Job Code: CD3216                      Project: Heyford Park Village Centre

Date Issued: 30/6/2017              Revision: S2-P2

Building 455 - Proposed East Elevation  
1 : 100

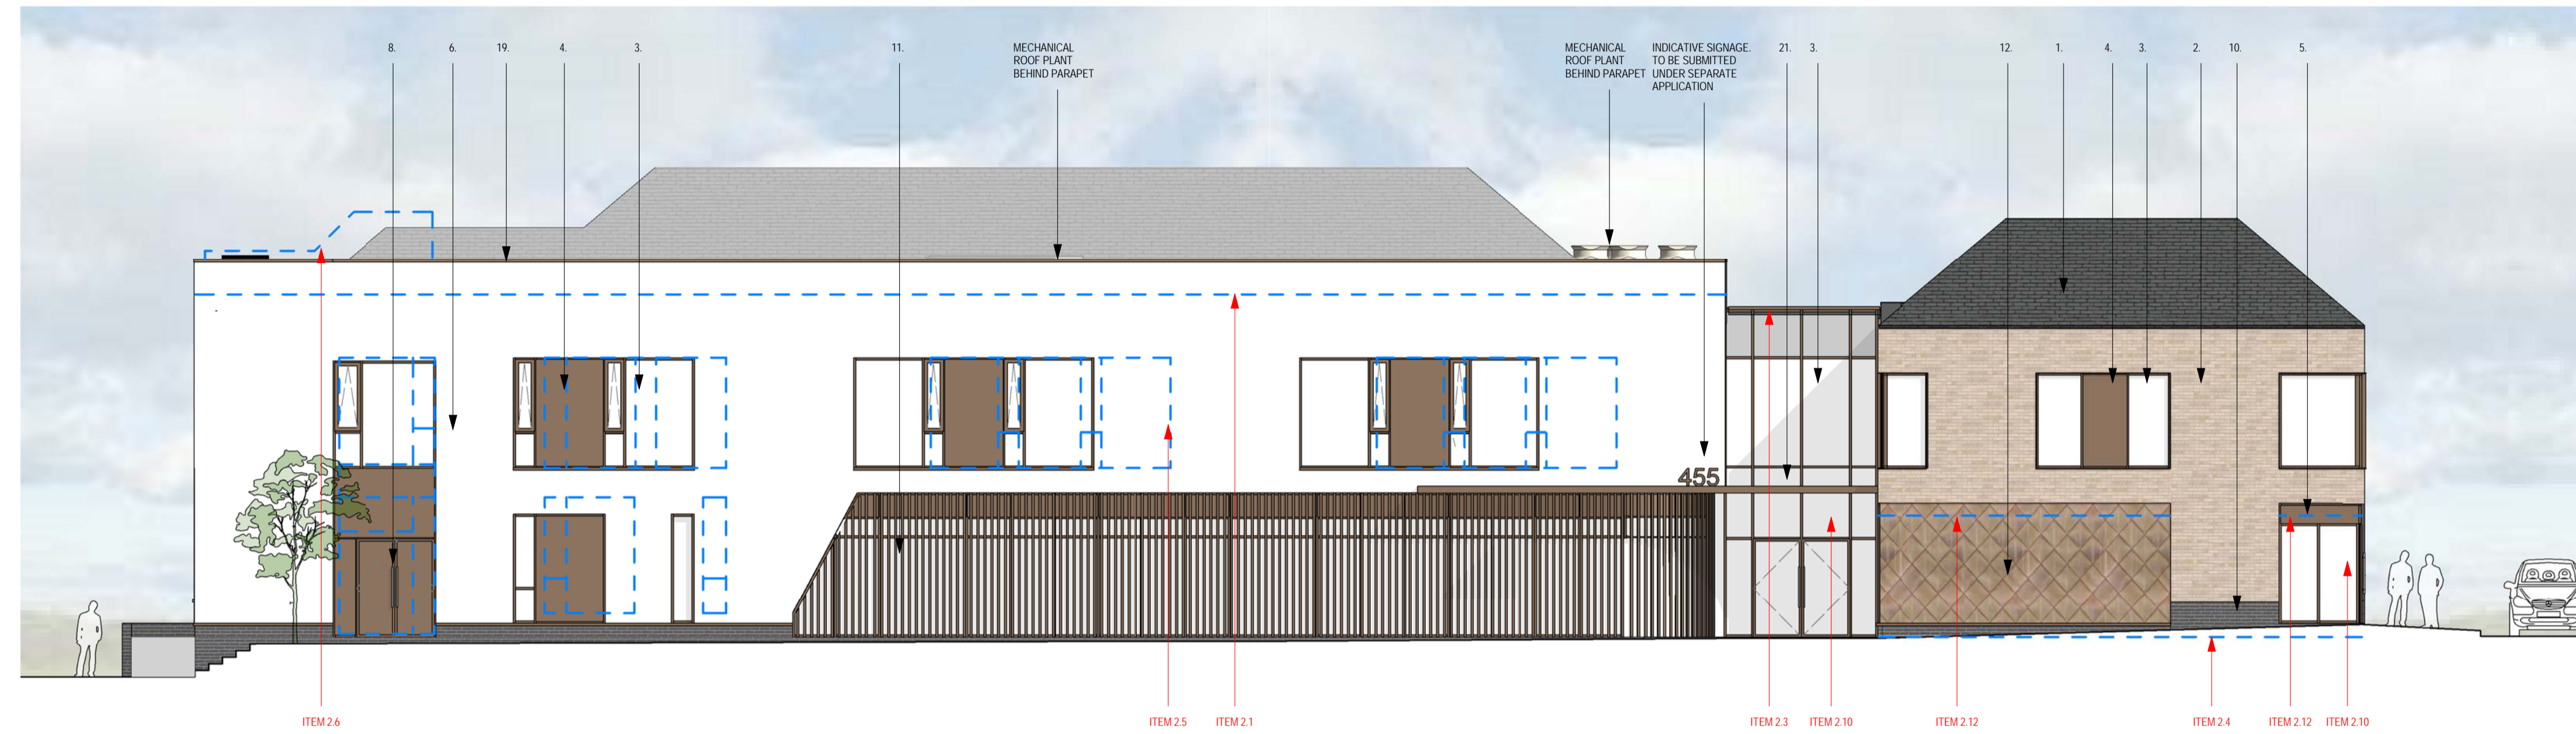
2.1	Increased height of flat roof, plant deck and parapet over new build elements due to coordination of structural frame and M+E services (1100mm high parapet required from a CDM standpoint to avoid the need for a mansafe/ fall-arrest system)

2.2	Introduction of incoming Gas/ Electrical Meter Rooms at ground floor to Camp Road frontage, which requires external access.
2.3	Omission of glazed roofs over first floor circulation areas due to overheating risk and to allow services to run in ceiling void. Individual rooflights to provide natural daylighting.

2.4	Floor in Estate's Office raised to allow for level threshold from Camp Road frontage (final FFL to be coordinated with external landscape design)
2.5	Reconfiguration of first floor hotel rooms 12-16 to accommodate relocation of Salon adjacent to front-of-house stair and passenger lift (retains security to hotel rooms via restricted public access); External windows repositioned accordingly

2.7	Final Exit door added to ground floor 'front of house' stair to provide safe escape for users on the first floor in the event of a fire.
2.8	External door from screening room removed as is not necessary for fire escape purposes.

2.9	Bathrooms to hotel rooms reconfigured to allow for drainage. External windows adjusted accordingly
2.10	Glazed elements broken down into glazing modules and glazed spandrel panels added.

2.11	Glazed link to Building 455 fully glazed – removal of existing brickwork nib following advice from structural engineer. Removal of existing hipped roof and replaced with flat roof following advice from structural engineer.

2.12	First Floor level increased to align with existing structure following site surveys.
2.13	Dark grey brick plinth added, following design development

2.14	Final exit ramp added to rear fire exit to provide level/ramped access following updated measured survey information.
2.15	Rotating entrance door replaced with automatic sliding doors following design development.
<b>3.0</b>	<b>Building 457</b>

Building 457 - Proposed South Elevation
1 : 100

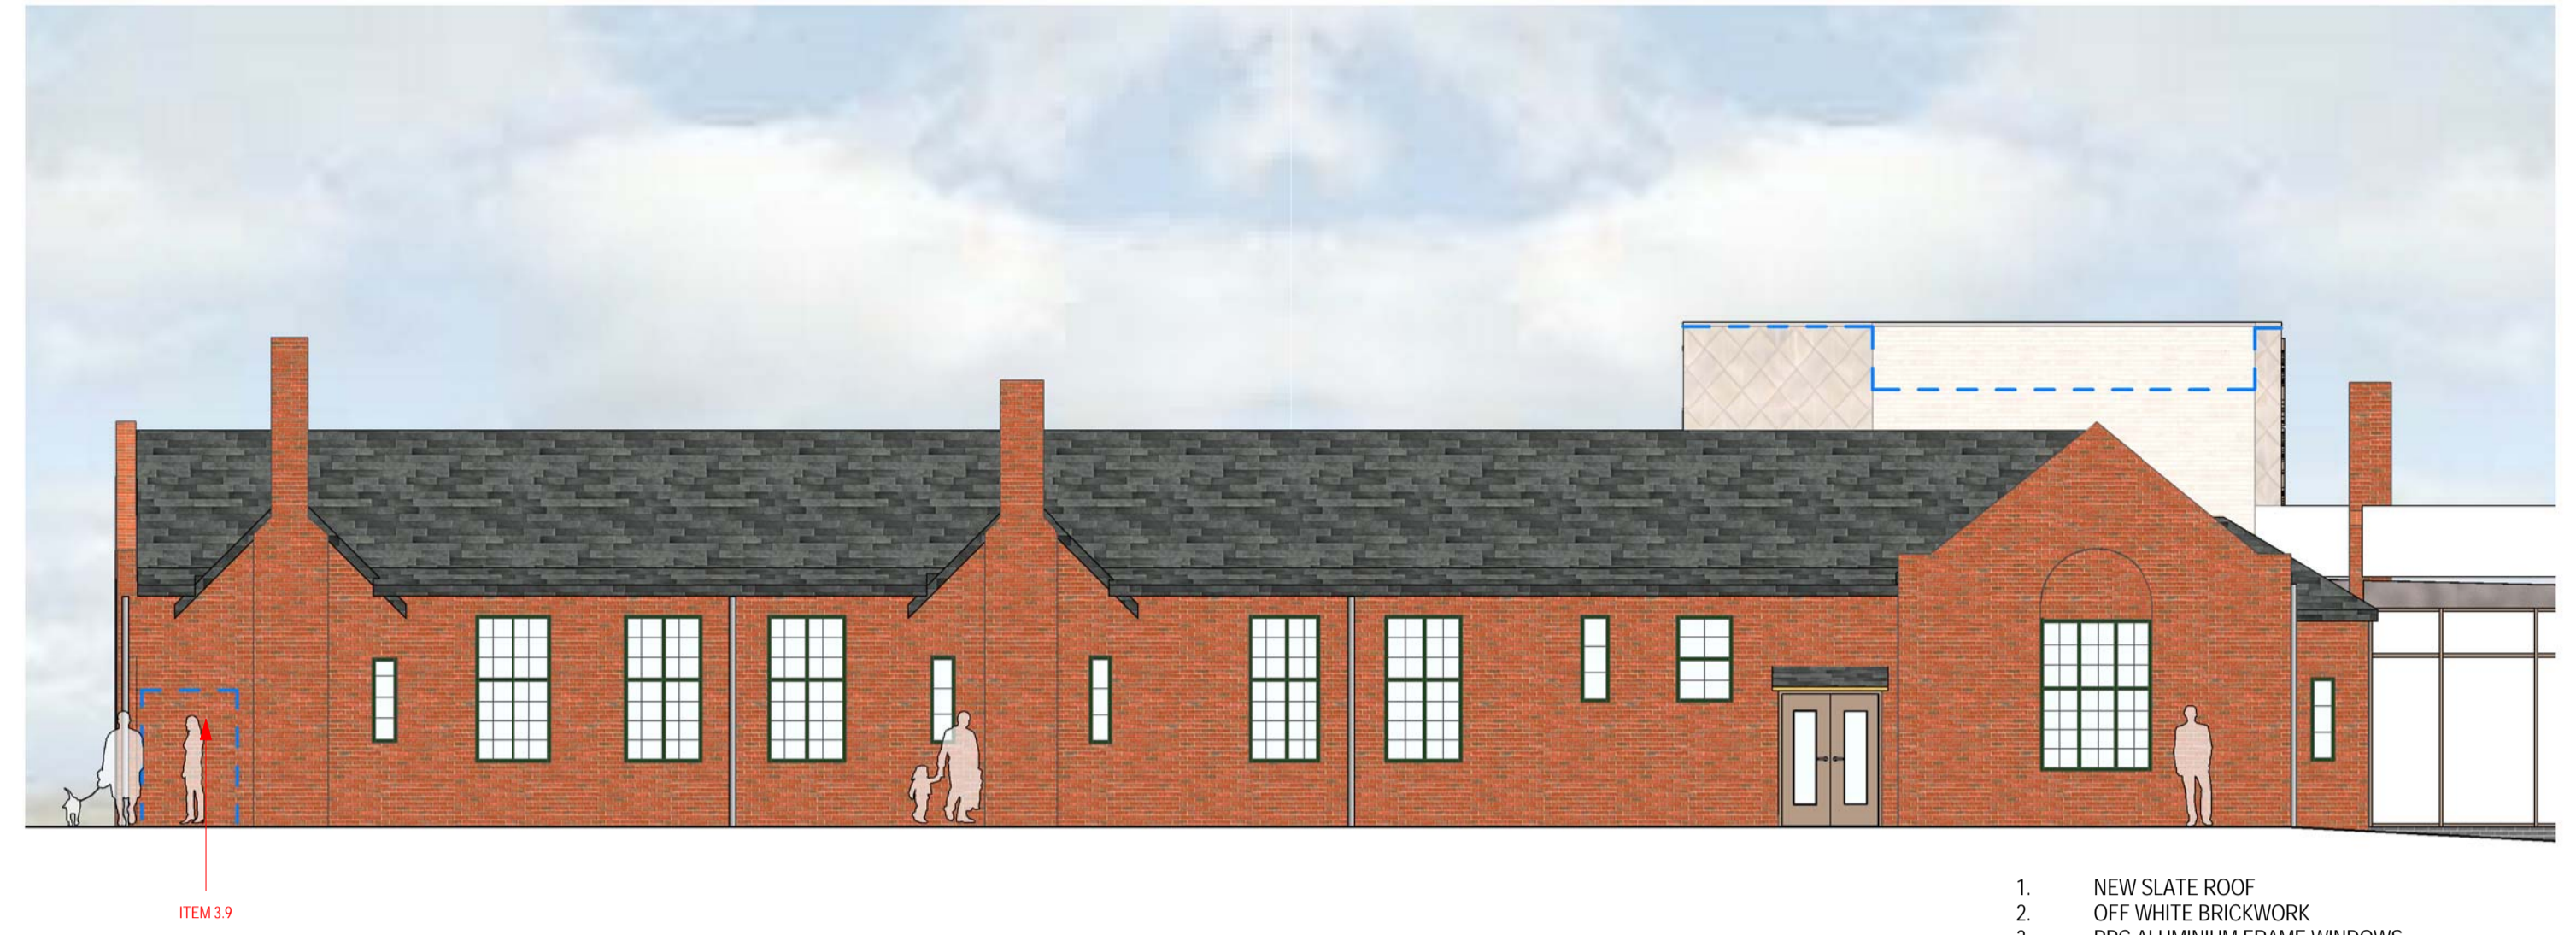
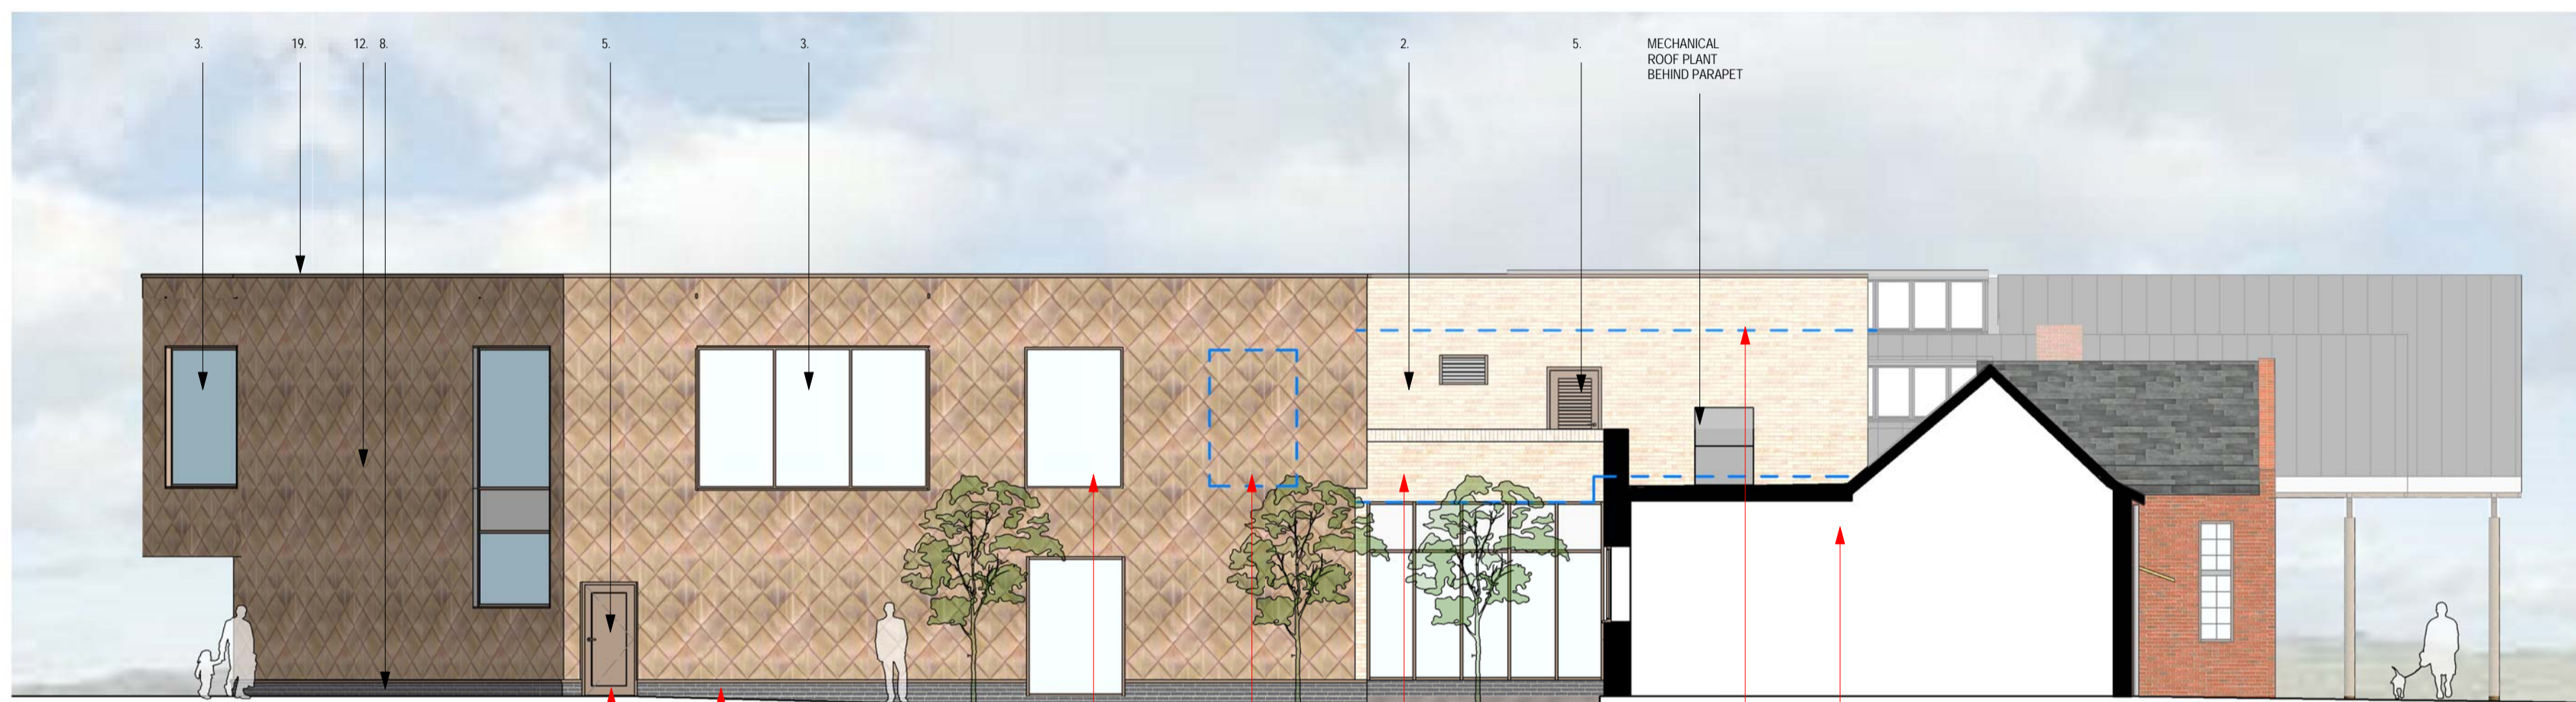
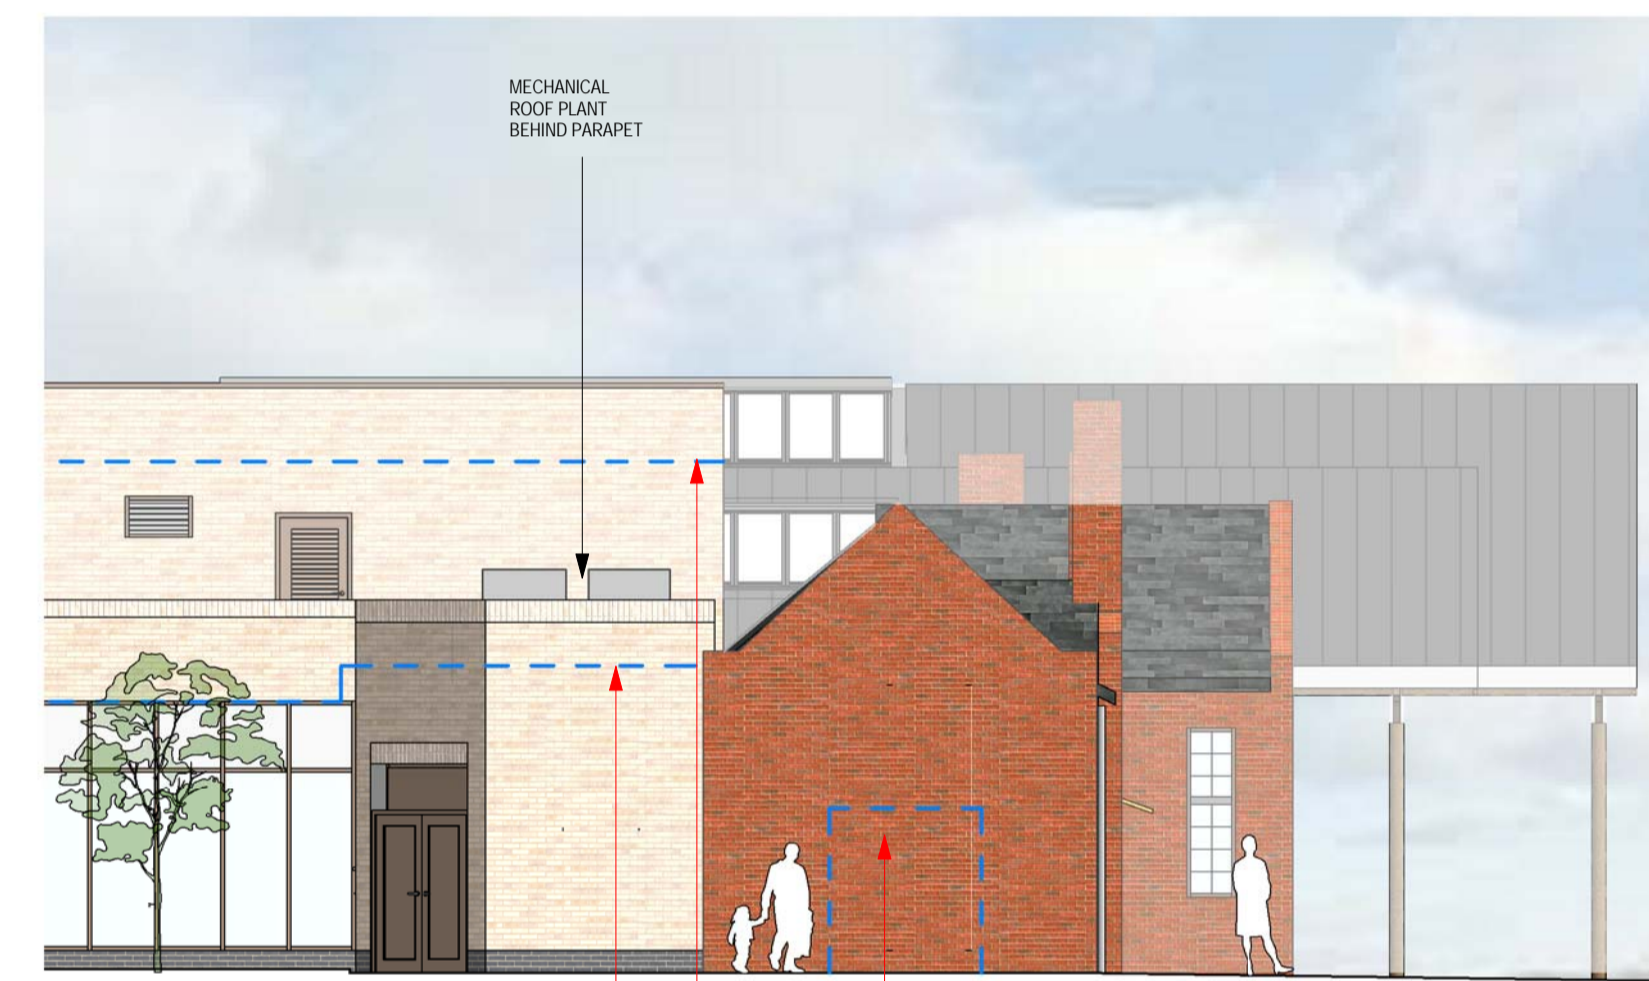
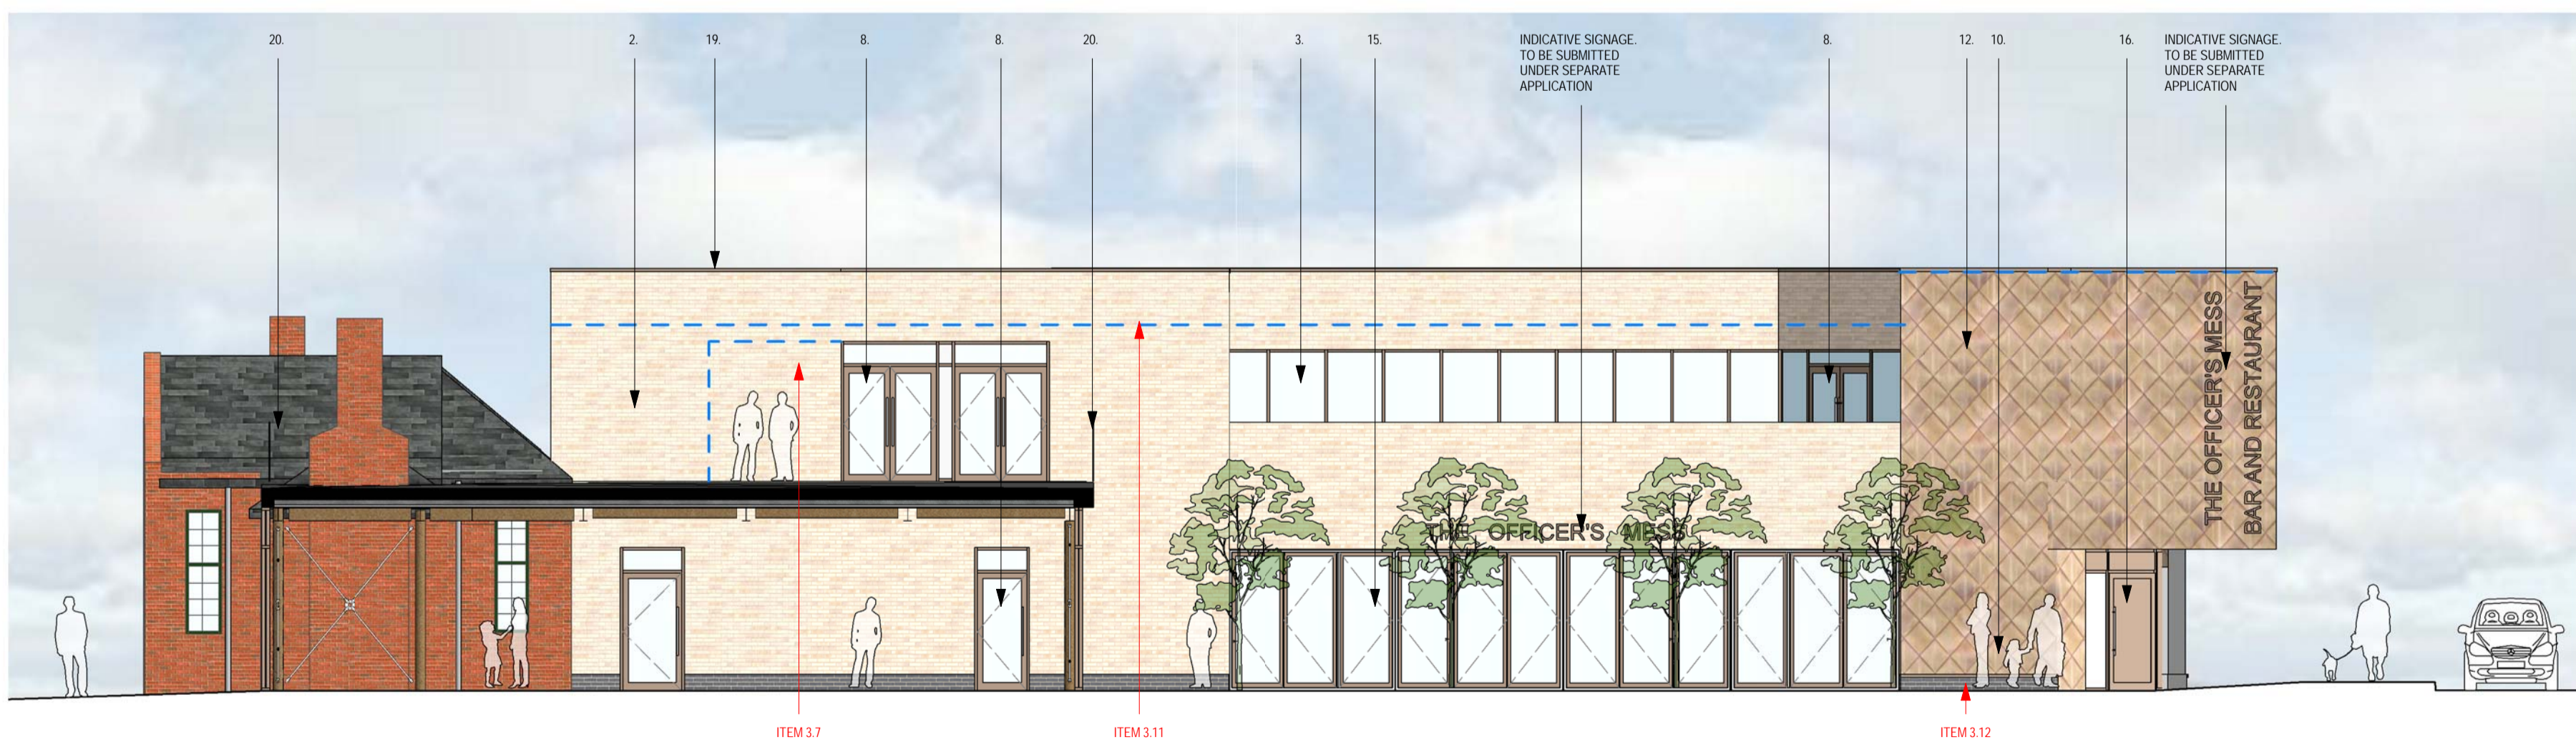
3.1	Increased height of first floor FFL, flat roof, plant deck and parapet over new build elements due to coordination of structural frame and M+E services (1100mm high parapet required from a CDM standpoint to avoid the need for a mansafe/ fall-arrest system to plant deck.

3.2	Refuse Store and Plant Room rearranged at ground floor to enable easier distribution of M+E services throughout the building and to reduce duct lengths/ sizes. Additional door added to accommodate M&E requirements

3.3	Omission of glazed roof over ground floor circulation areas (replaced with insulated flat roof with single-ply membrane) and increased height of parapet for continuous 1100mm parapet around roof plant area.

3.4	Adjustments to ground and first floor WC arrangements to enable efficient coordination of SVP's/ drainage connections and has led to subsequent relocation of external windows.

3.5	Demolition of existing 'spine wall' to back of house area due to potential instability during construction works.
3.6	Fire exit door added to Stair 1 to provide those evacuating from the first floor immediate exit to outside once down the stairs.

3.7	Removal of single leaf door on first floor to terrace
3.8	Removal of double doors to existing western gable elevation following reconfiguration of restaurant and kitchen layout.

3.9	Removal of double doors to existing south elevation following reconfiguration of internal restaurant and kitchen layout.
3.10	First Floor level increased following updated measured survey information.

3.11	Increased height of first floor FFL, flat roof, plant deck and parapet over new build elements due to coordination of structural frame and M+E services . Masonry elements increased to allow for this space and align with metal cladding elements (removal of 1100mm parapet as no roof plat to this area.)

3.12	Dark grey brick plinth added, following design development
3.13	Window replaced with door to provide external delivery access to Bar Store
<b>4.0</b>	<b>Covered Link</b>
